CITY OF ALBUQUERQUE

RE: **Lot 3 Block 9 Unit 5 SAD 227**
Unser Cliffs
6212 Kayenta Dr. NW
Grading and Drainage Plan
Engineers Stamp Date 12/30/19 (E10D647)

Based upon the information provided in your submittal received 12/30/19, this plan cannot be approved for Grading Permit until the following comments are addressed.

ENGINEER'S SEAL	6212 KEYENTA PLACE	DRAWN BY DEM
DAVID SOULE NEW MEXICO 14522 REGISTERED PROFESSIONAL ENGINEER	GRADING AND DRAINAGE PLAN	DATE 12-29-19
1/3/19		6212 KEYENTA PLACE.DWG
DAVID SOULE P.E. #14522	1606 CENTRAL AVENUE SE SUITE 201 ALBUQUERQUE, NM 87106 (505) 972-0899	SHEET # C1
		JOB #

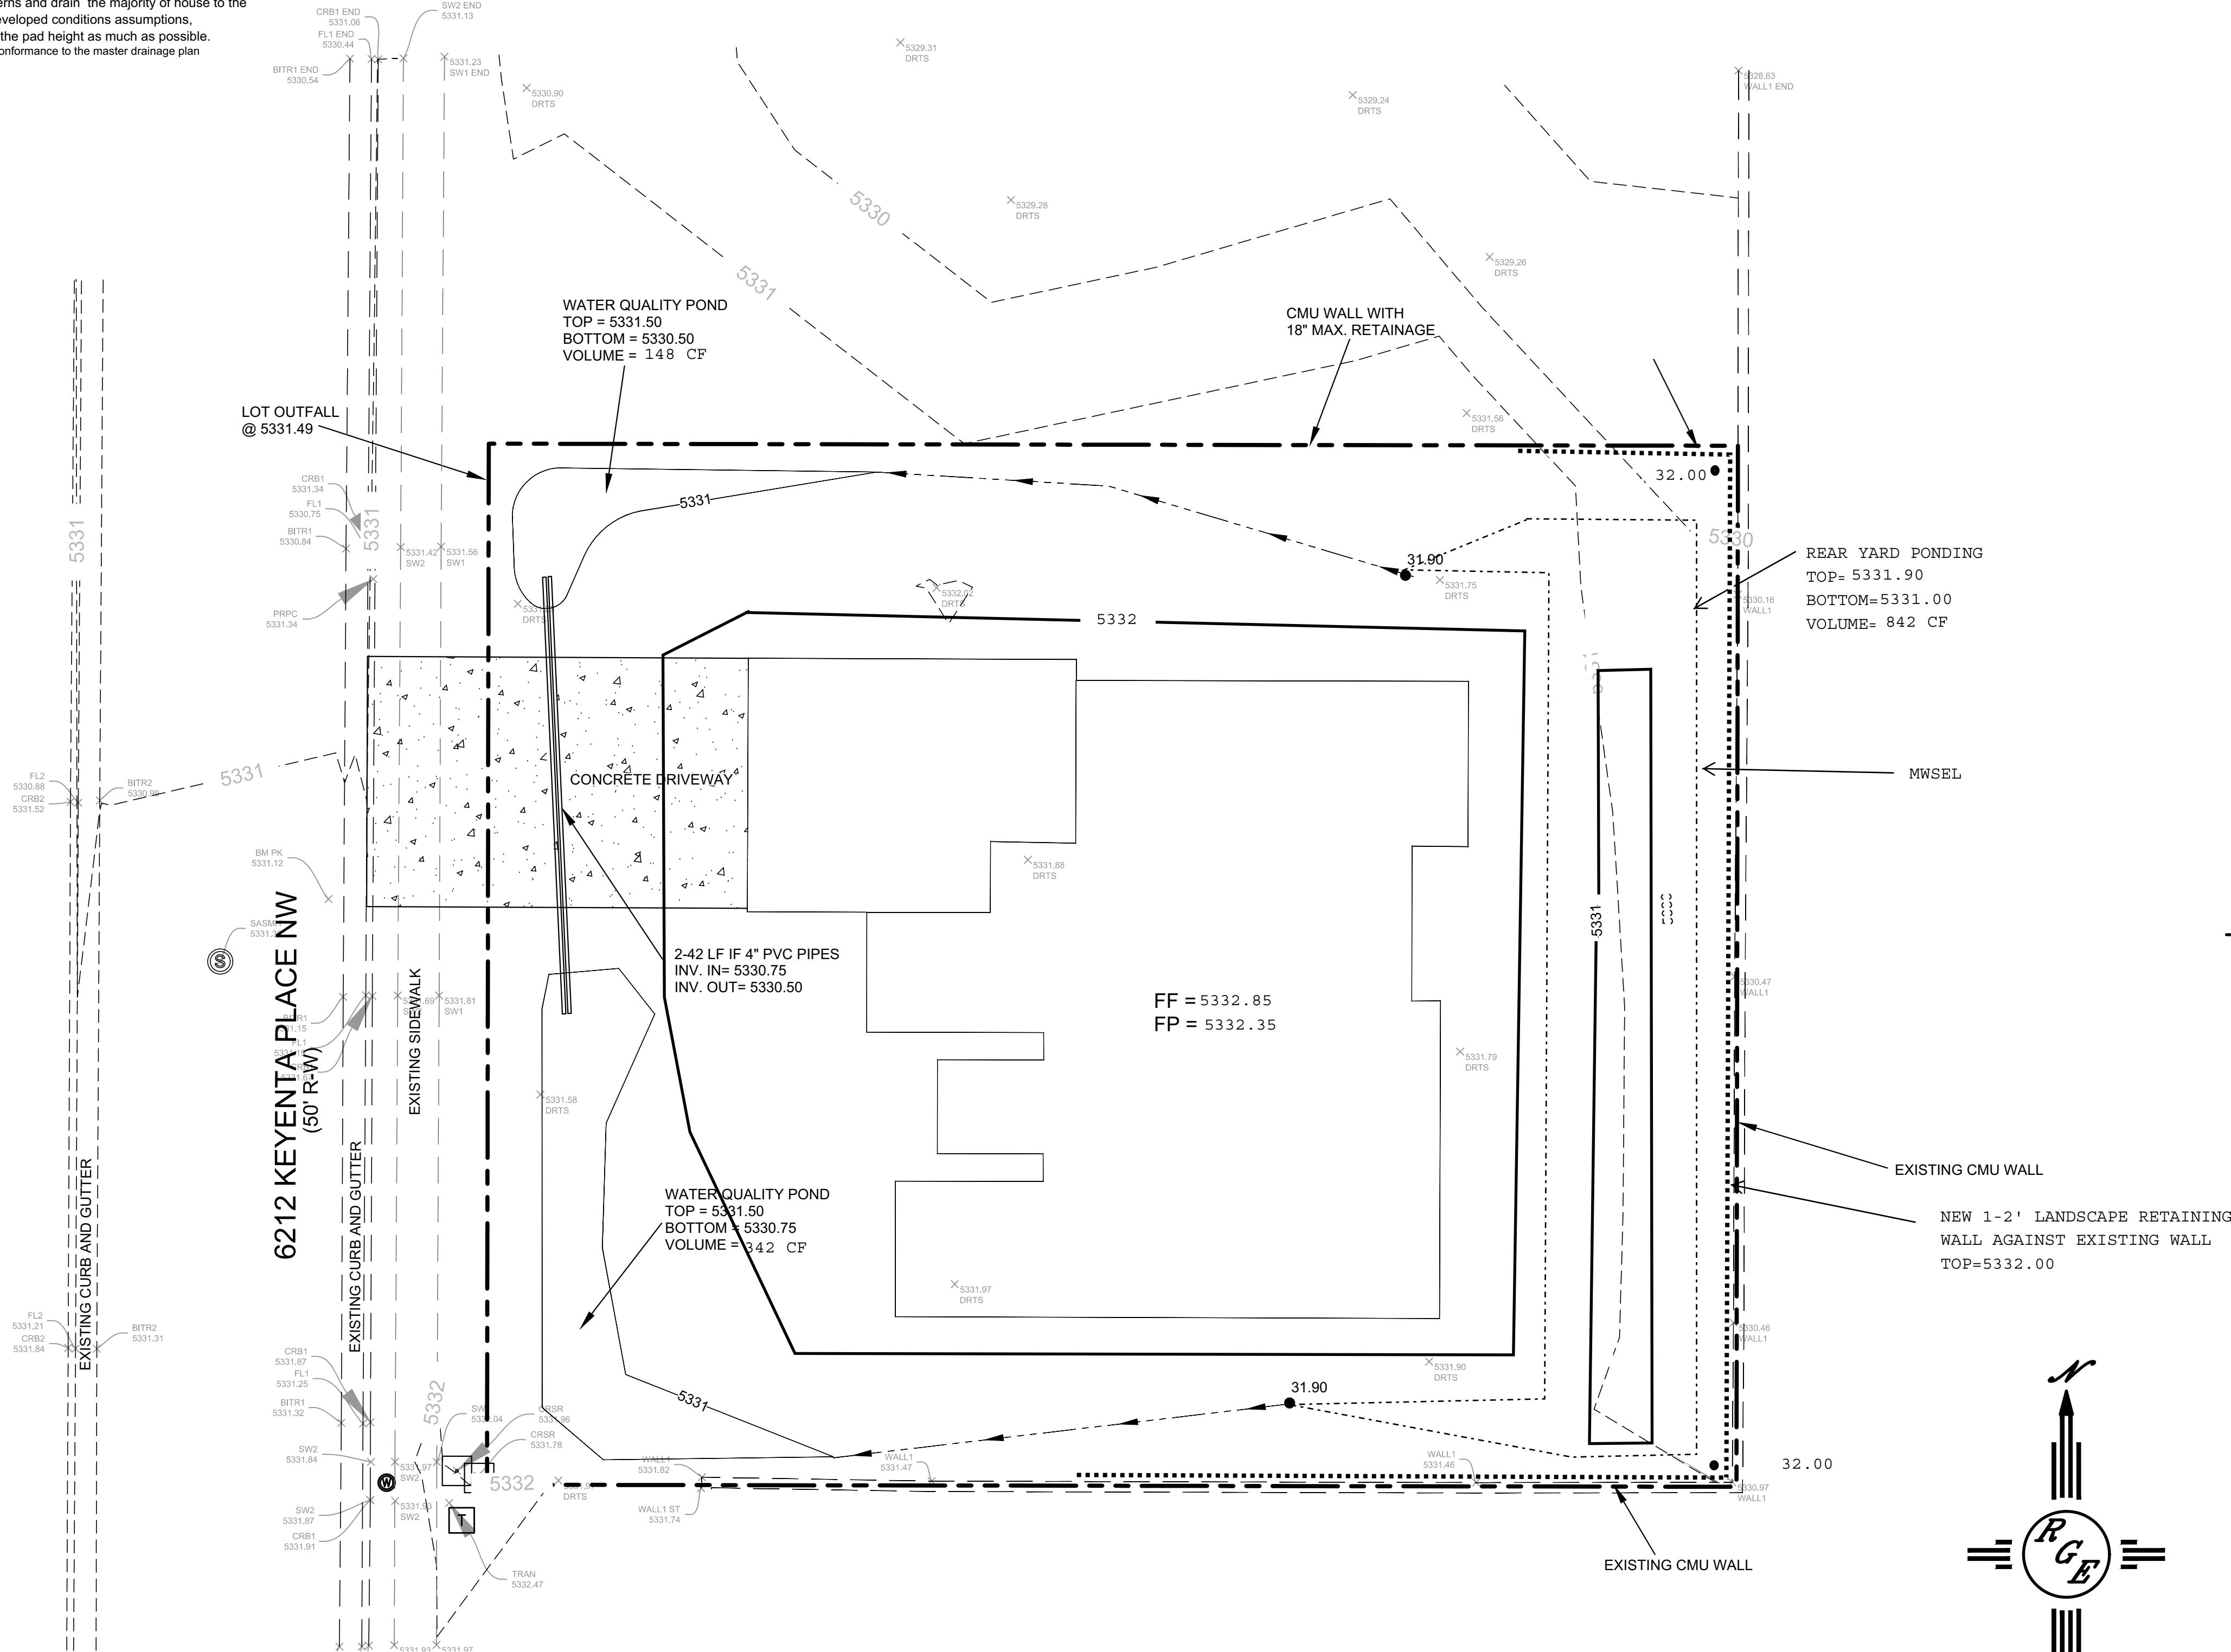
- Make all flows exit out onto Kayenta Dr.
- Inform Owner/Contractor not to use dirt as a ramp to climb curbing or drive over the sidewalk. Only crusher fines or lumber may be used for this process.
